20120009 SOPA Response

**Re: Axis Development
State Significant Development Application Site 43/44
Australia Avenue, Sydney Olympic Park**

Further to receipt of the Sydney Olympic park Authority letter dated the 7th of June 2013, find below the following responses:

BASEMENT 2 PLAN

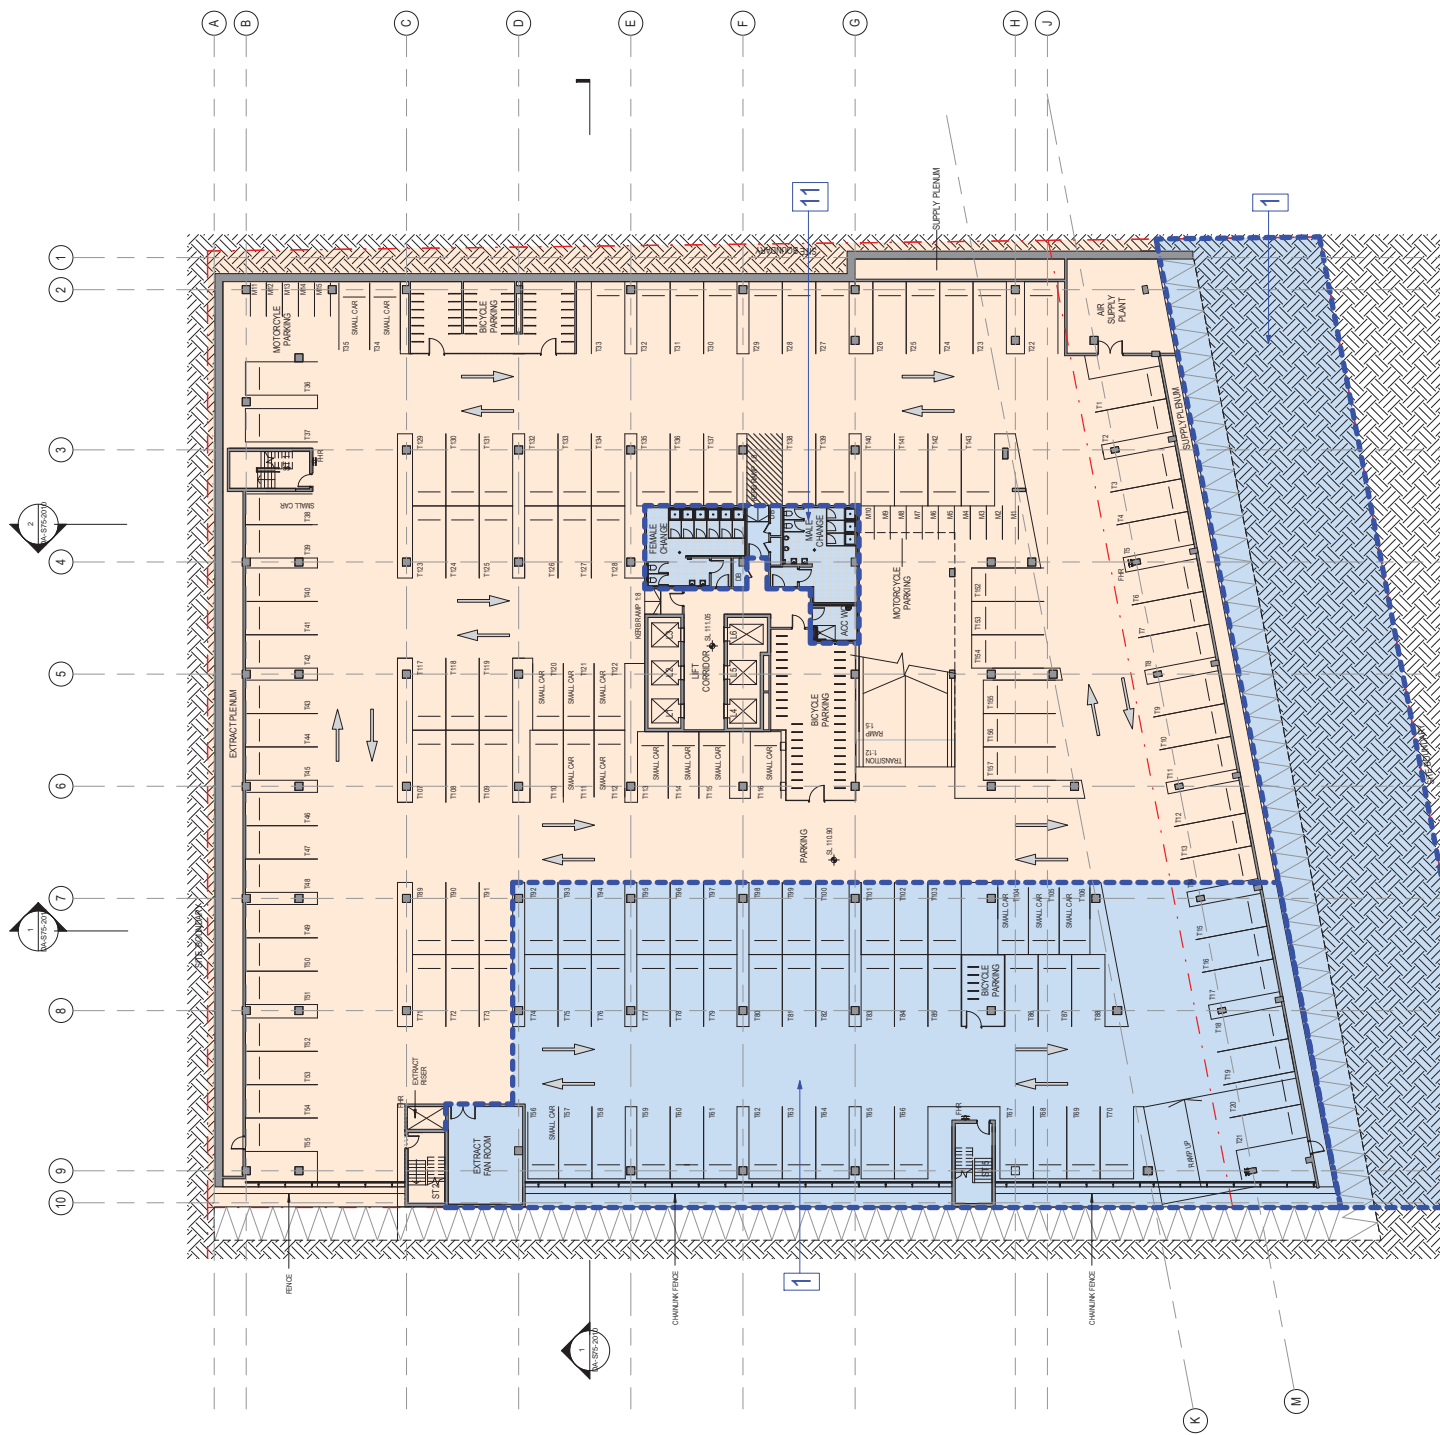
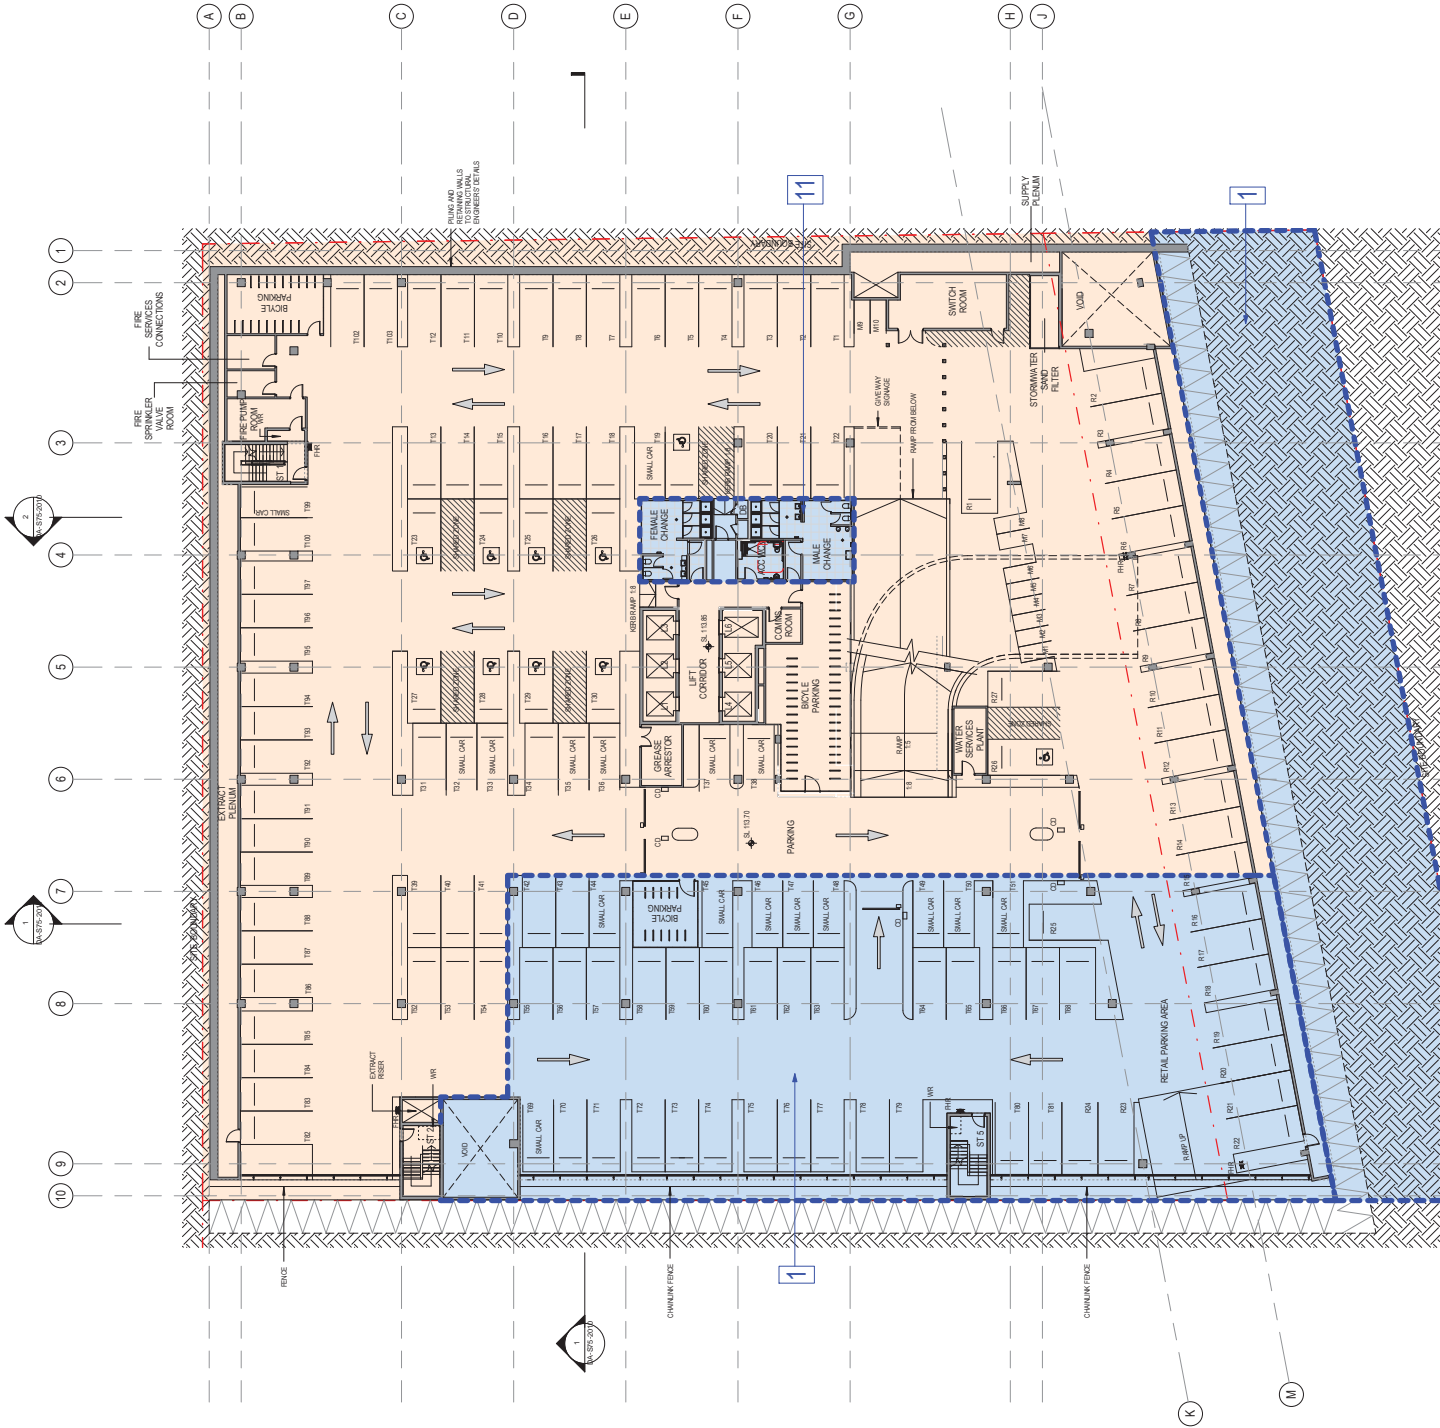
Consistent with SOPA's policy basement car parks over ten spaces must include oil & grease trap capable of meeting a discharge concentration <10mg/L of total hydrocarbons.

The pollution control devices (gross pollutant traps) have been indicated on our drawings for both Stage 1 and Stage 2 as attached below. All carpark area drainage has been configured to be treated by these pollution control devices prior to discharge from the site. At this time the actual models of equipment have not been selected due to the contract being on a D&C basis. The requirement for the equipment has however been included, and the SOPA performance standards will be met.
